Mr and Mrs W Lima
43 Northaw Road East
Cuffley
Hertfordshire
EN6 4LU

Reference No: 6/2015/2223/HOUSE
45 Northaw Road East, Cuffley, Herts, EN6 4LU
Erection of single storey side and rear extensions and extension to the roof to form habitable accommodation

Side Elevation (North facing) Proposed

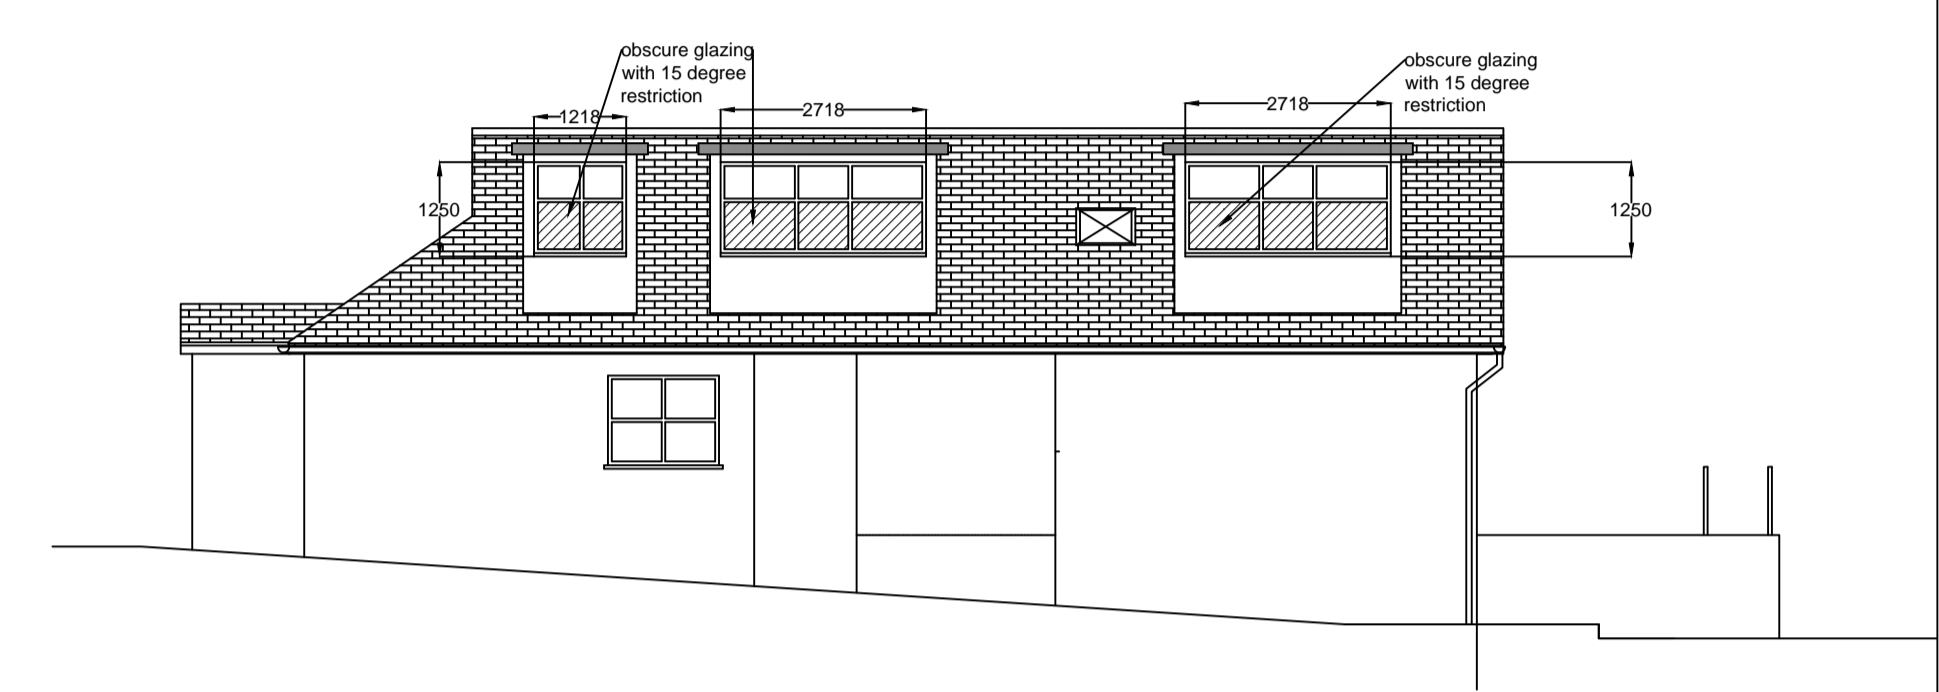
The report continues with consideration of the dormer windows facing your property and states that, in the opinion of the case officer, there would not be any resulting loss of privacy. The case officer only considers that a condition requiring obscure glazing would be appropriate for the windows facing south, towards number 47 Northaw Road East.

At this point it should be noted that the aforementioned condition, in order to obscure those south facing dormer windows, was not included on the final planning permission and I recognise that this is an error on behalf of the Council.

Finally, I can advise that Chris Carter (Principal Planning Officer) has repeatedly sought, via their planning agent, the agreement of the owner of the application property to the obscure glazing of the dormer window to the front of their property that would face towards you. However, at the time of writing, this agreement has not been forthcoming.
